Darling Square W1 Student Accommodation Development Consultation Outcomes Report

Date:
4 September 2015

Drawing Title
NORTH & EAST ELEVATIONS

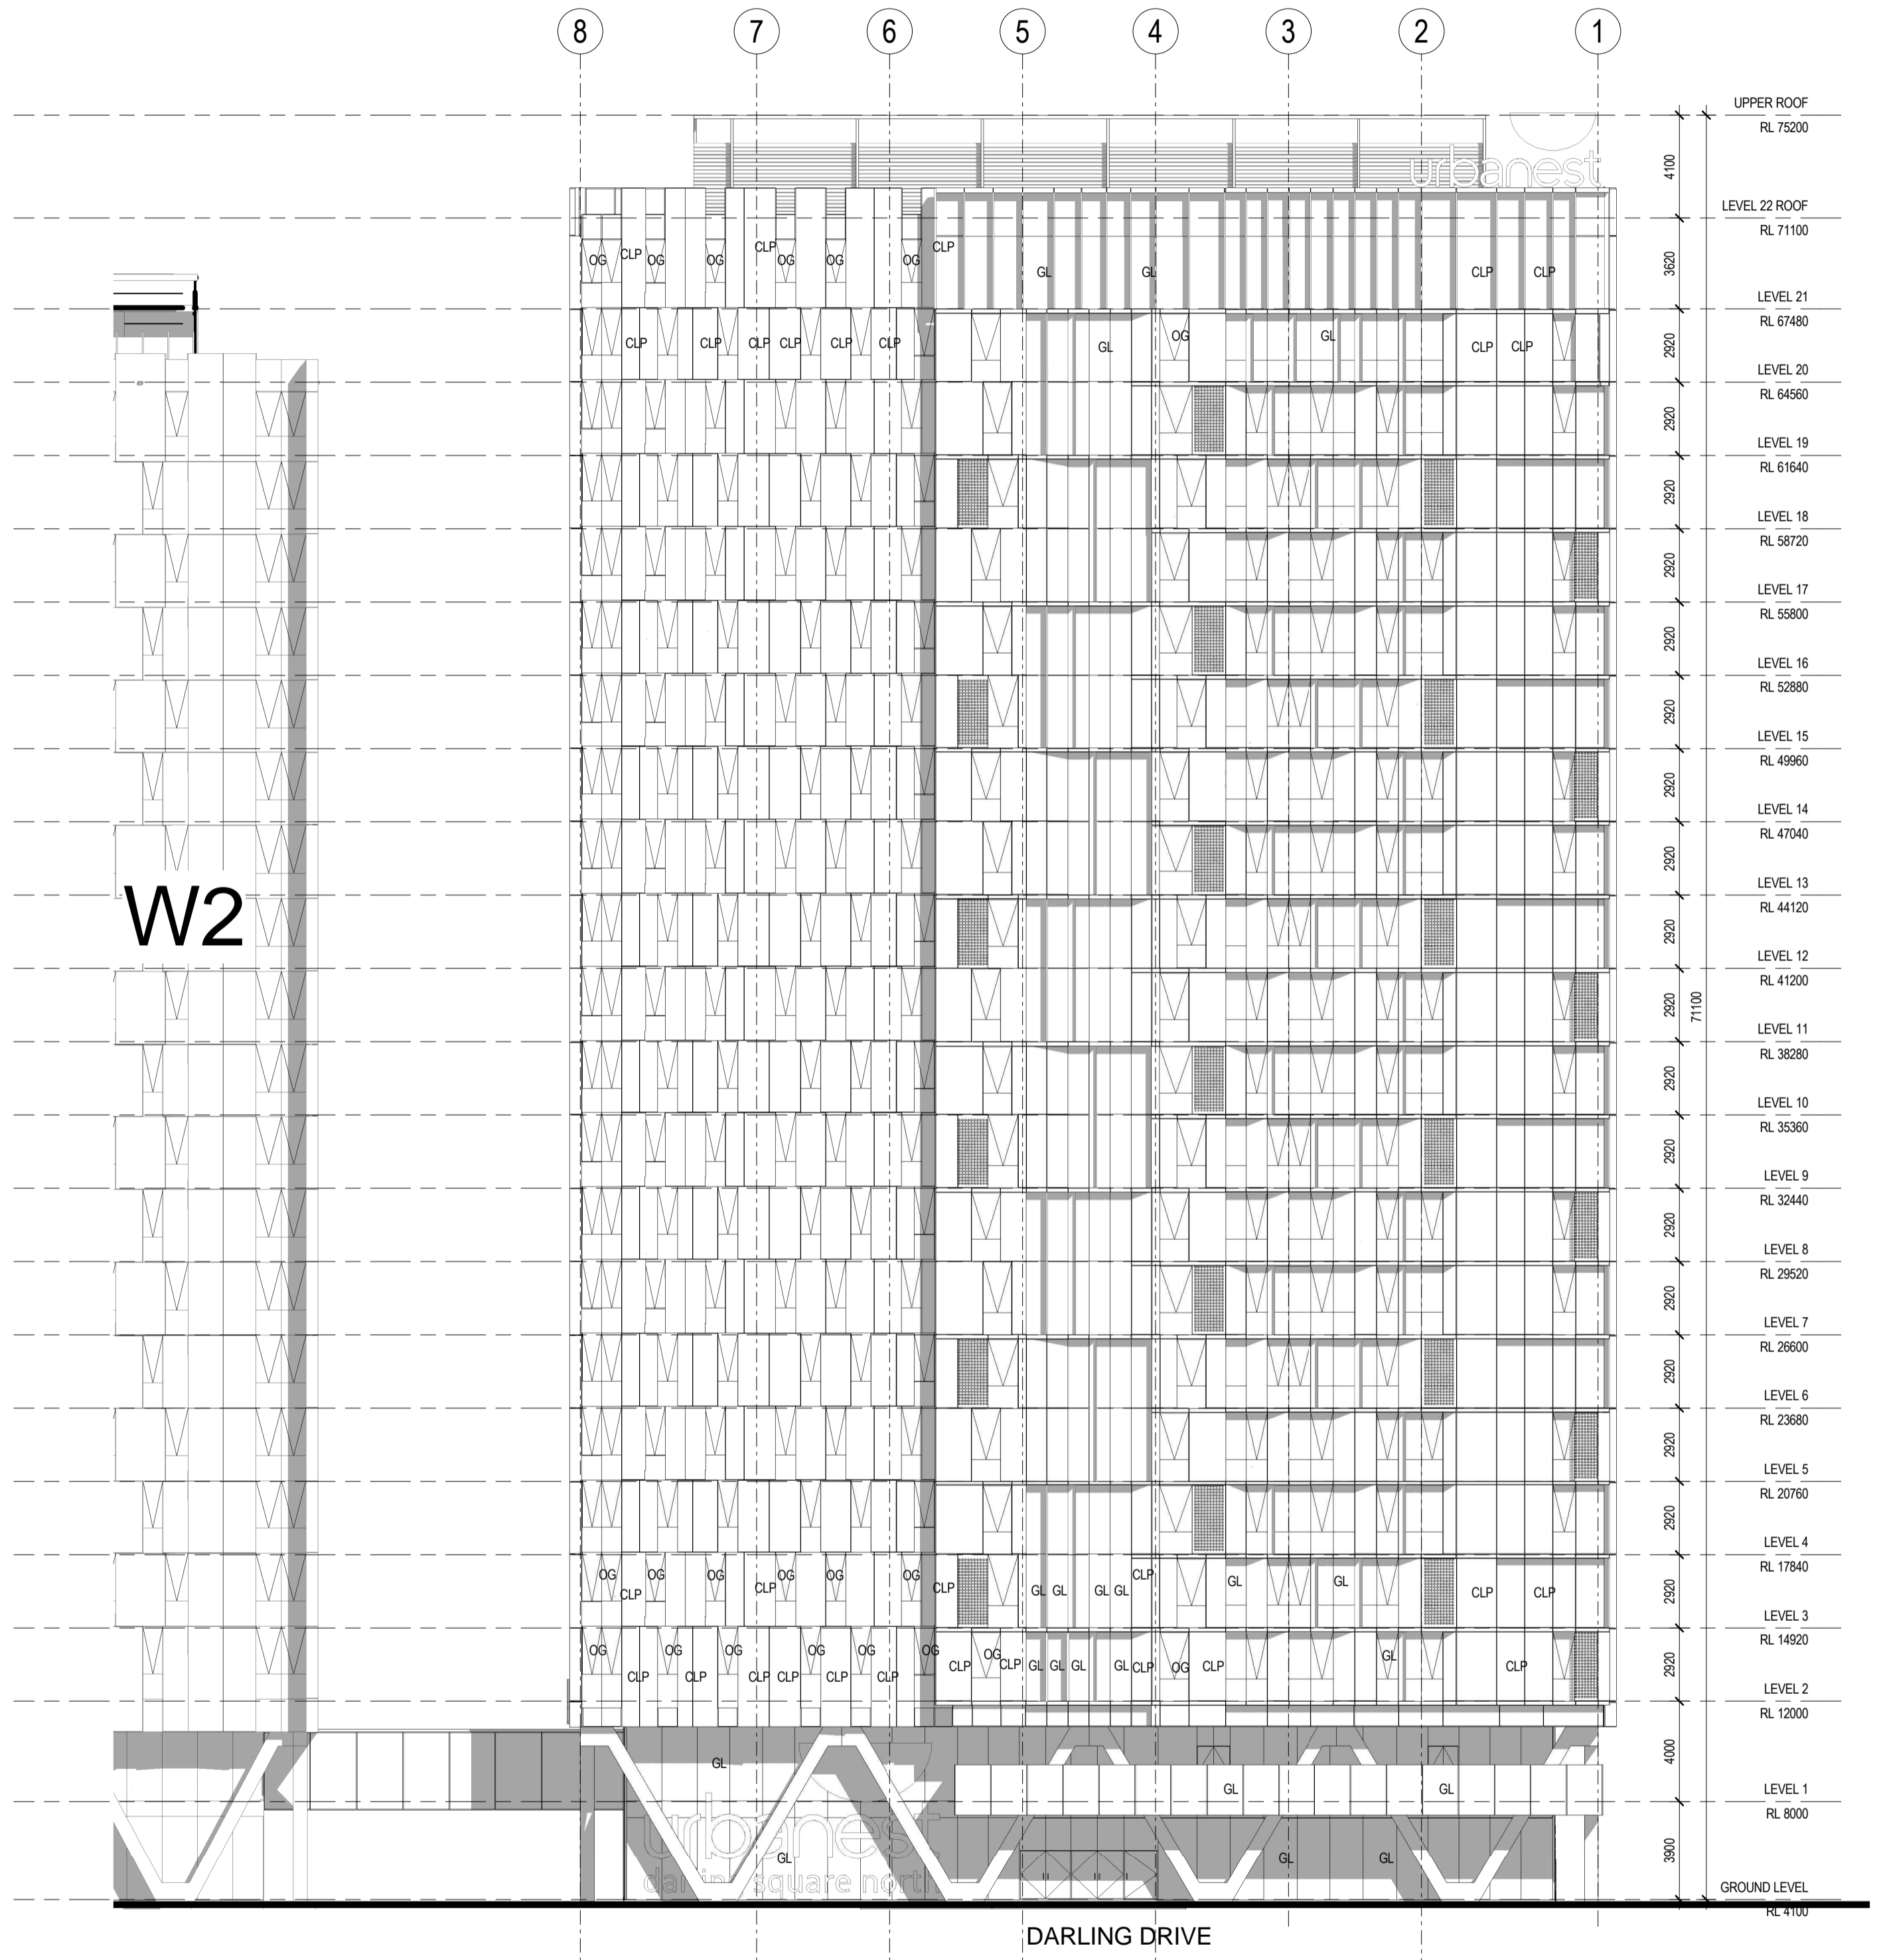
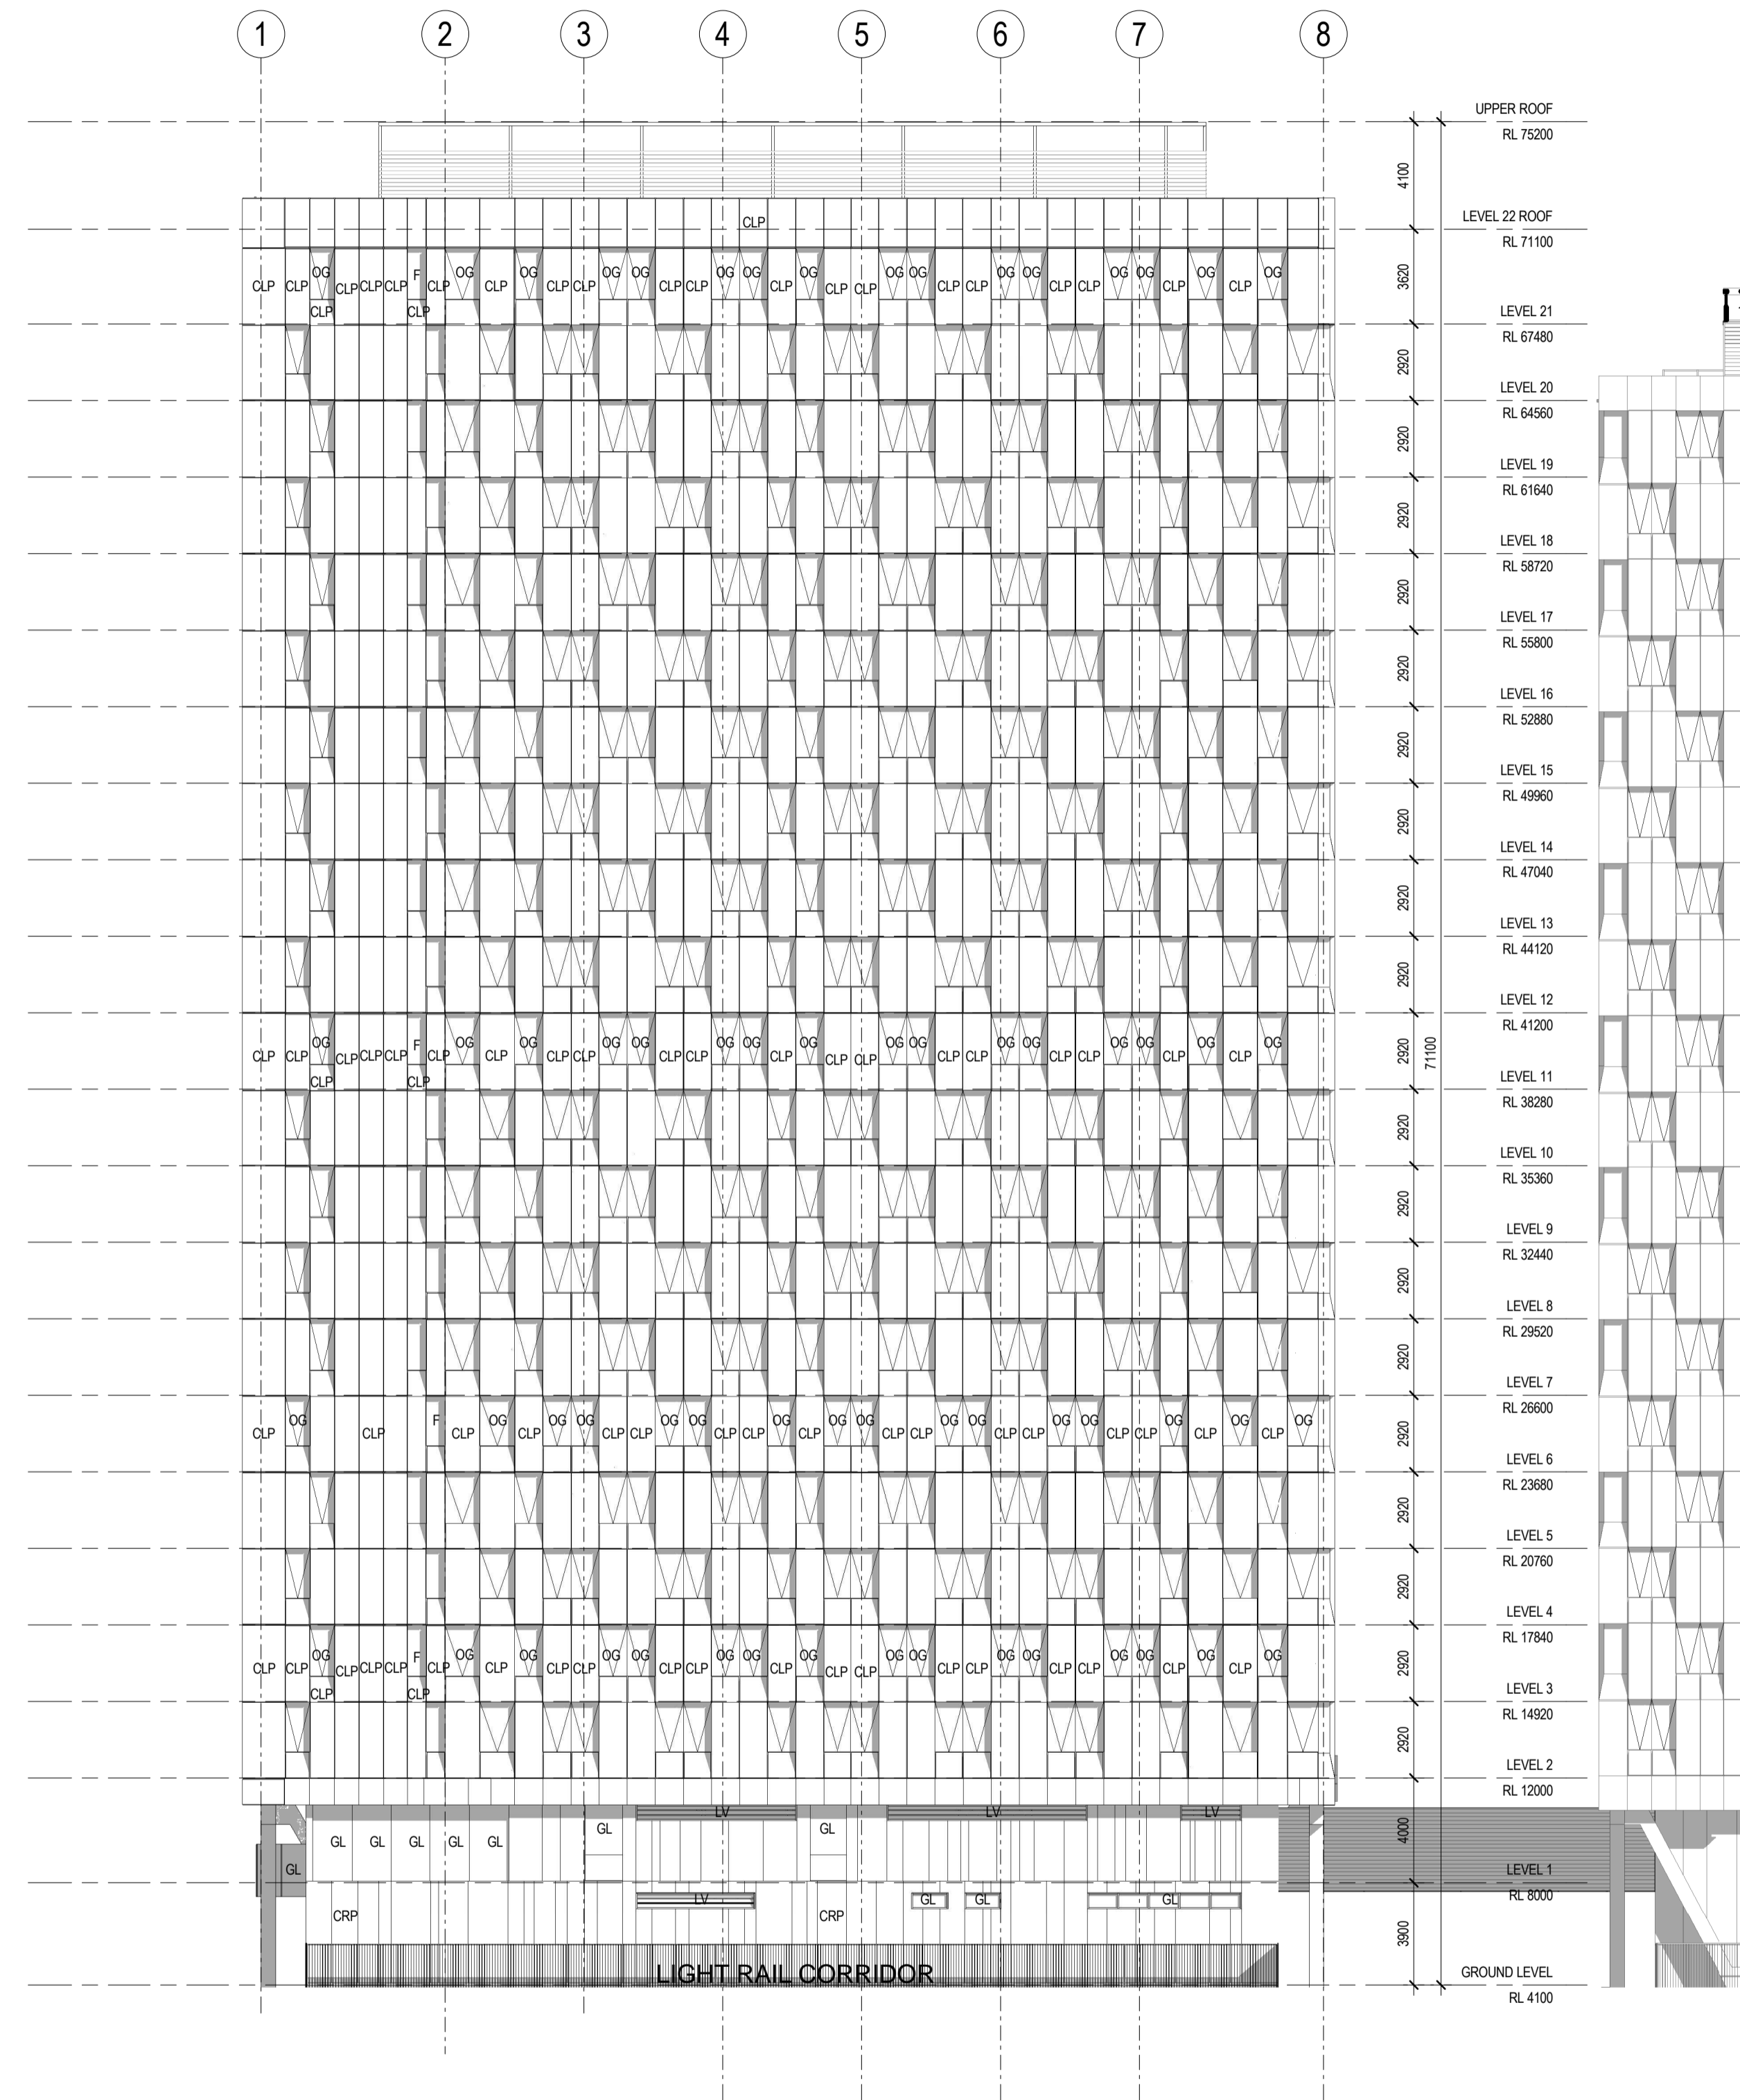
- Windows of the western and northern facades (ground and Level 1) should be reviewed in terms of reflectivity. Window tinting or screening may be required to reduce reflectivity.
- Consideration should be given to the reflectivity of external signage (tram signals are white and red lights)
- All balustrades on the side of the building facing the train line should be high enough to prevent items being thrown on the tracks
- Consideration should be given to the management of foot traffic at the Hay St intersection
- Potential for activating the northern pocket park should be investigated
- There was a query regarding the size of the bedrooms in relation to the DCP requirements.
